Subject: BE/121/21/RES-Unit 3 Land At Salt Box West of Shripney Road Bognor Regis PO22 9NW

I have reviewed the latest plans for this application. There still appears to be conflict between the proposed tree and drainage. As you suggested, it may be best to just replace this tree with hedging. We would recommend that the species is selected from the list within section 4 of the Southern Water tree planting guide, which can be found here: <https://www.southernwater.co.uk/media/1642/ds-tree-planting-guide.pdf>

UNITS 3
DRAINAGE LAYOUT

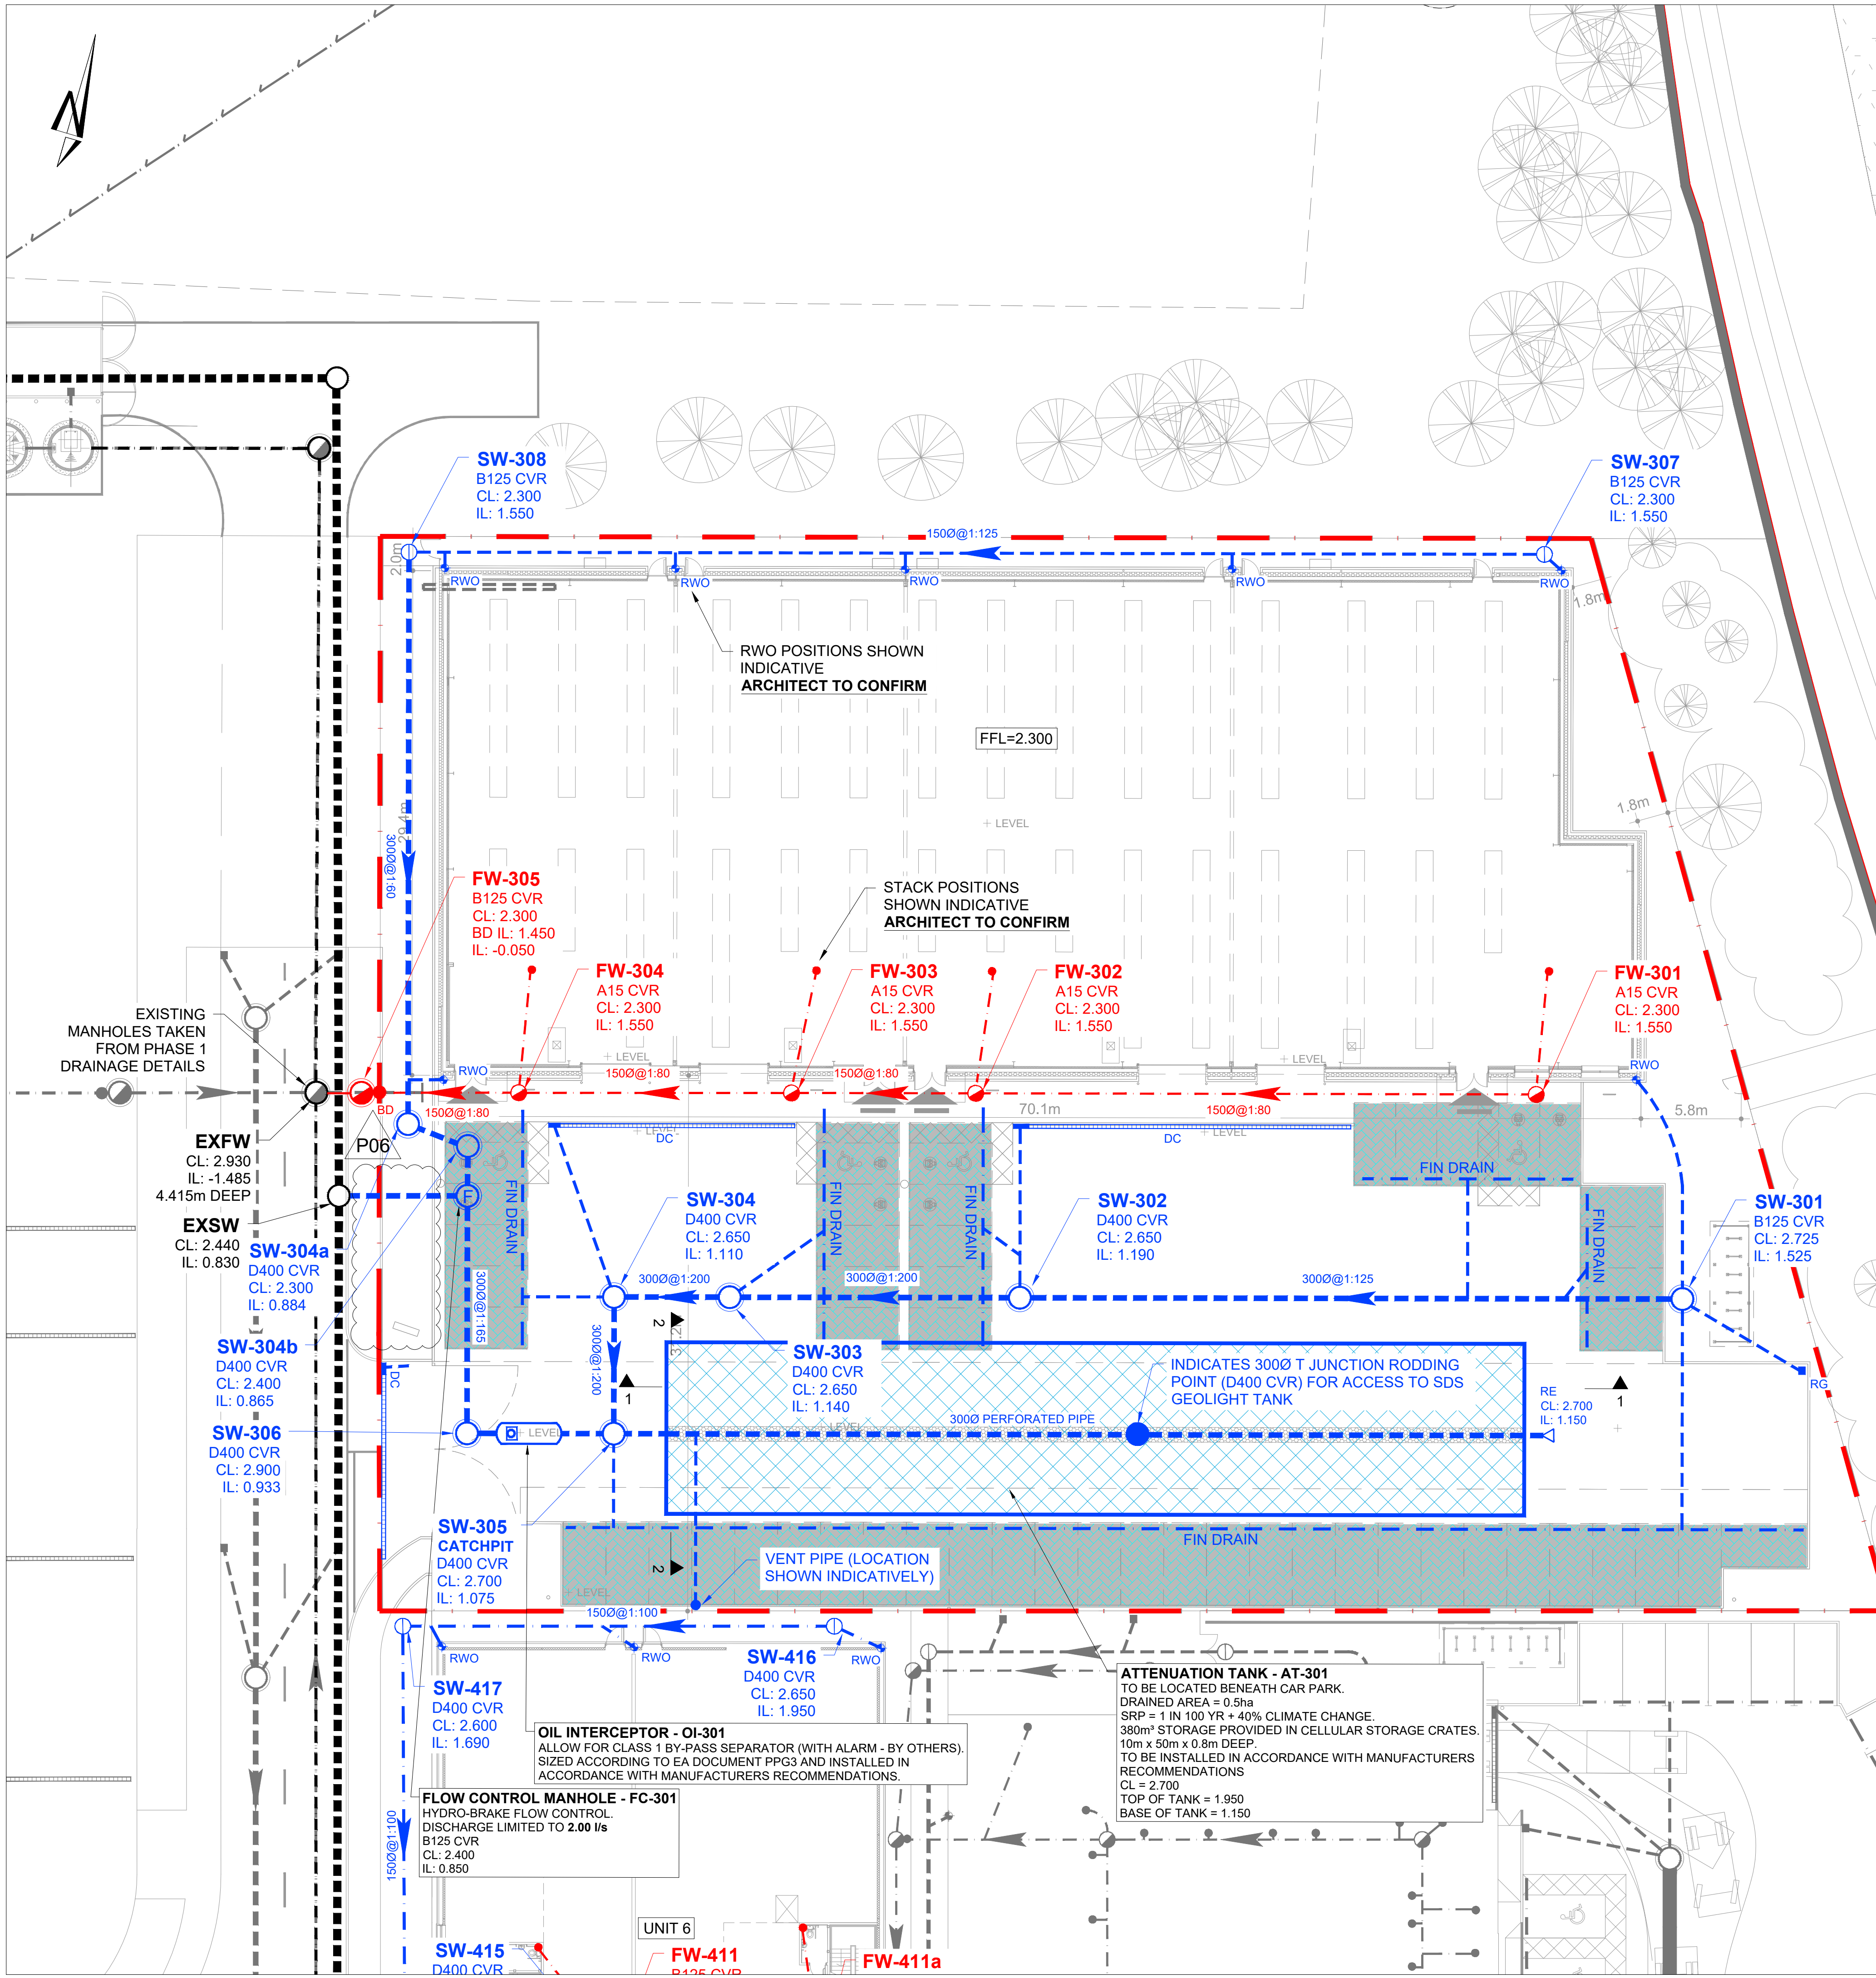
Please ensure that the drainage plans are NOT listed as approved.
